Application No: AW/66/22/HH  
Site Address: 36 Kingsway Aldwick PO21 4DH  
Description of works: Addition of a first floor with pitched roof to the existing flat roof garage. This application affects the character & appearance of the Craigweil House Conservation Area.

OWPC46919

Proposed East Elevation

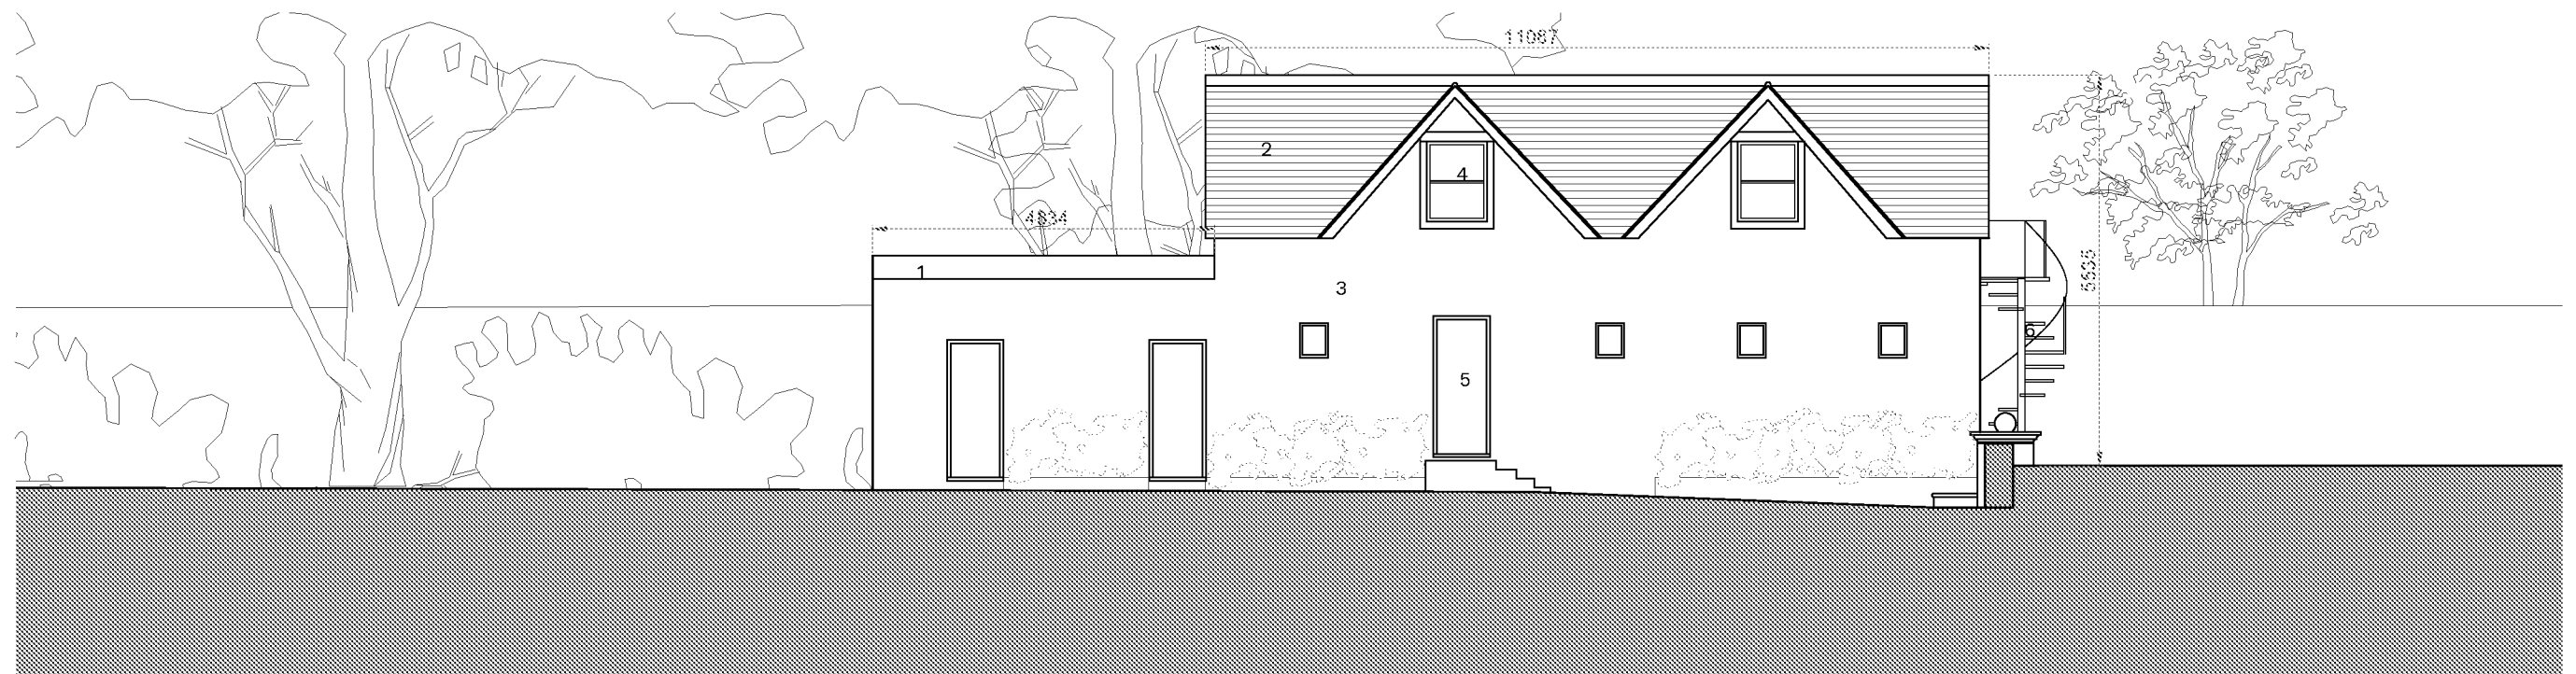
I wish to object to the proposed development due to the height of the proposed extension. The proposed East elevation shows a dimension of 5535mm to the ridge. This would be more than double the height of the existing building and would have a major adverse visual impact, particularly as it is located only 100mm from the boundary of the property. The mass of the proposed extension would look overbearing from nearby houses and would be detrimental to the character of the Conservation Area. If allowed to proceed, this development would have a negative effect on amenity for neighbours, in addition to overlooking and loss of privacy.
